State of Washington  
**DEPARTMENT OF FISH AND WILDLIFE**

**SUBJECT: SE-23-00016 Ritter Access Road**

NEW ROAD PROPOSAL -
APPLICANT -
JIM RITTER, POA
FOR WILLIAM P. WOODS, JR.
E-MAIL - JAMESRITTER@GMAI.
206-949-9143.

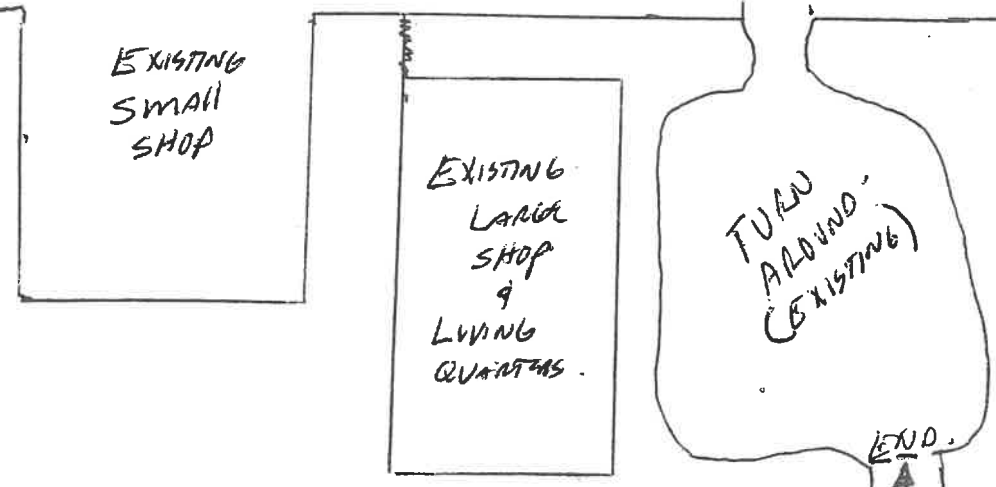
This project area is within the alluvial fan of the Wilson-Naneum Watershed. The Kittitas Reclamation District (KRD) canal north of the project area passes Mercer Creek and Wilson Creek through their canal and the KRD delivers irrigation water to this project area. During flood events, it is possible that all natural stream channels and irrigation delivery ditches will be conveying flood water. The design of the access road, berms and culverts may interrupt these flows and change the distribution of water during high and/or low flow conditions on this property and potentially other nearby parcels.

We encourage further review of how the road, as proposed, may impact critical areas such as frequently flooded areas and wetlands.
